Address: 466 Caprice St.
259 C021

CHECK-LIST AGAINST ZONING ORDINANCE

Proposed Use/Work - Single Family Residence 1,828 sf.
Attached garage - 528 sf.

TITLE:
ELEVATIONS

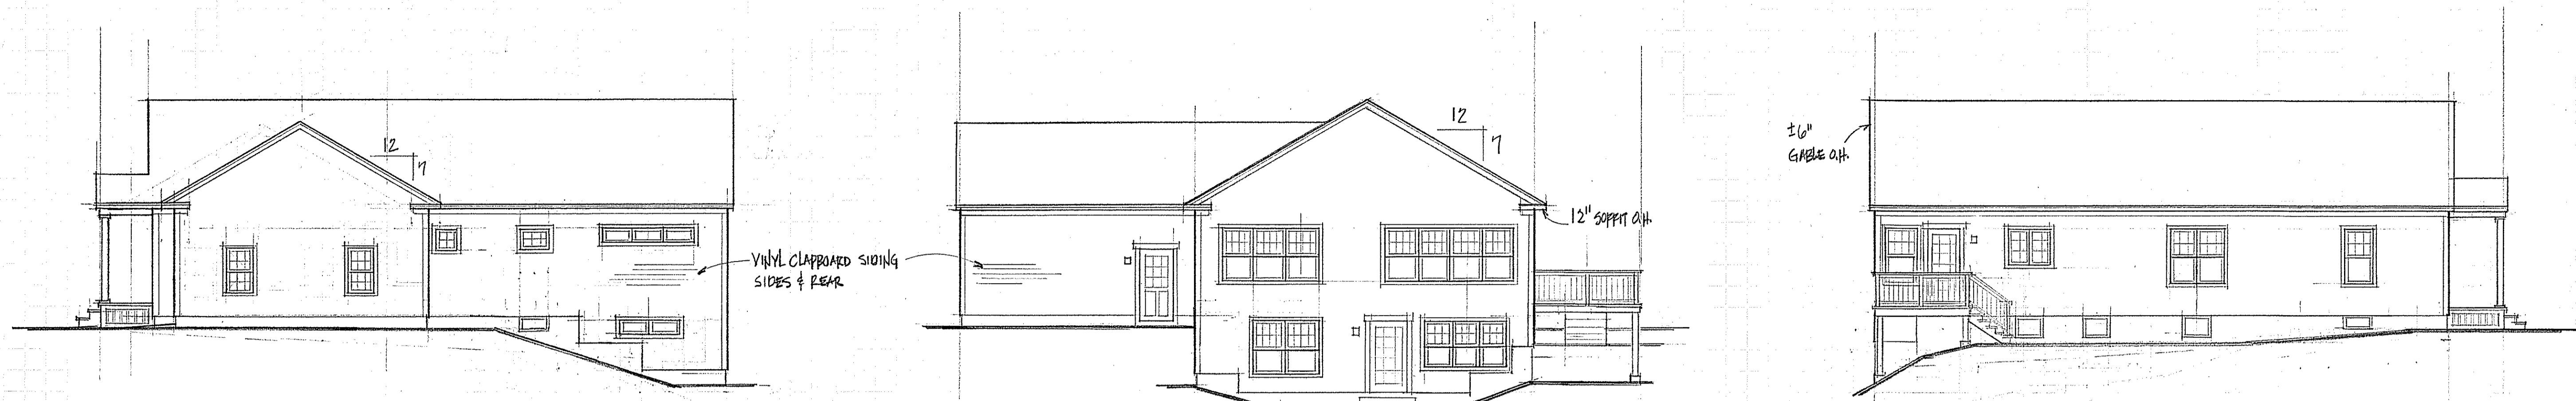
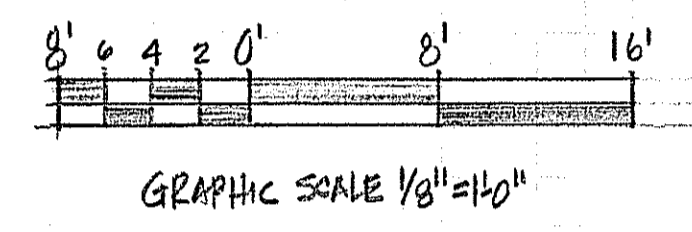
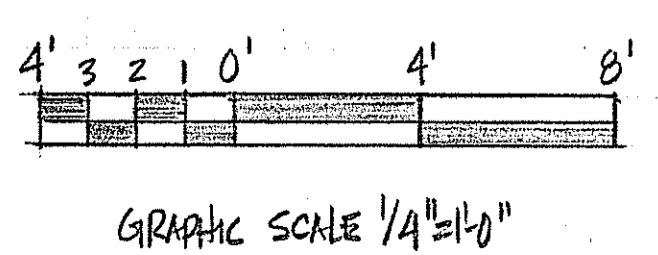
Height - max 35' allowed - 27' scaled from lowest grade to peak - OK

Partial daylight basement <50% does not count as story

SITE PLAN
 SCALE: 1"=50'
 GRAPHIC SCALE 1"=50'

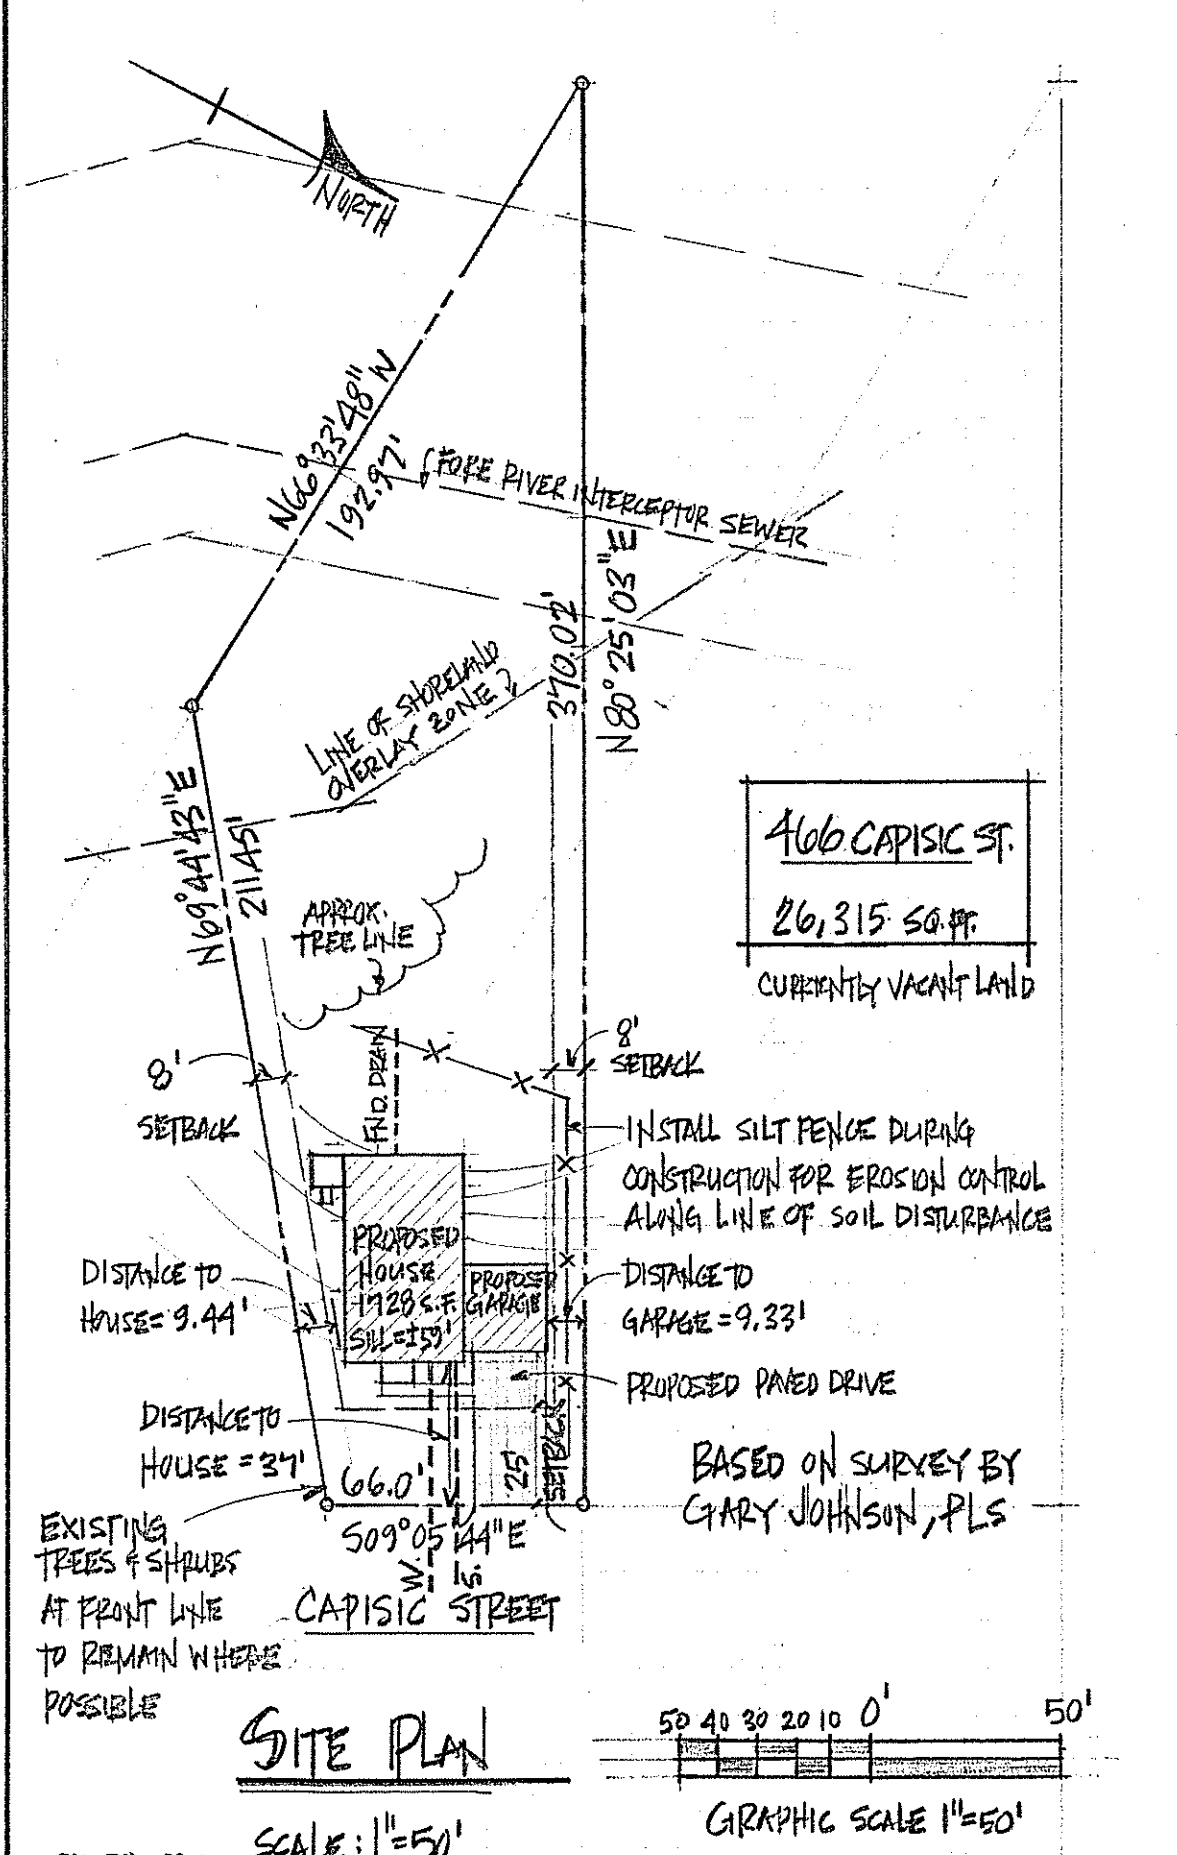
Front Yard - 32' scaled off plan - meets 25' min

Rear Yard - 130'+ scaled off plan - meets 25' min

Site Plan - Phil working on - requested add'l info
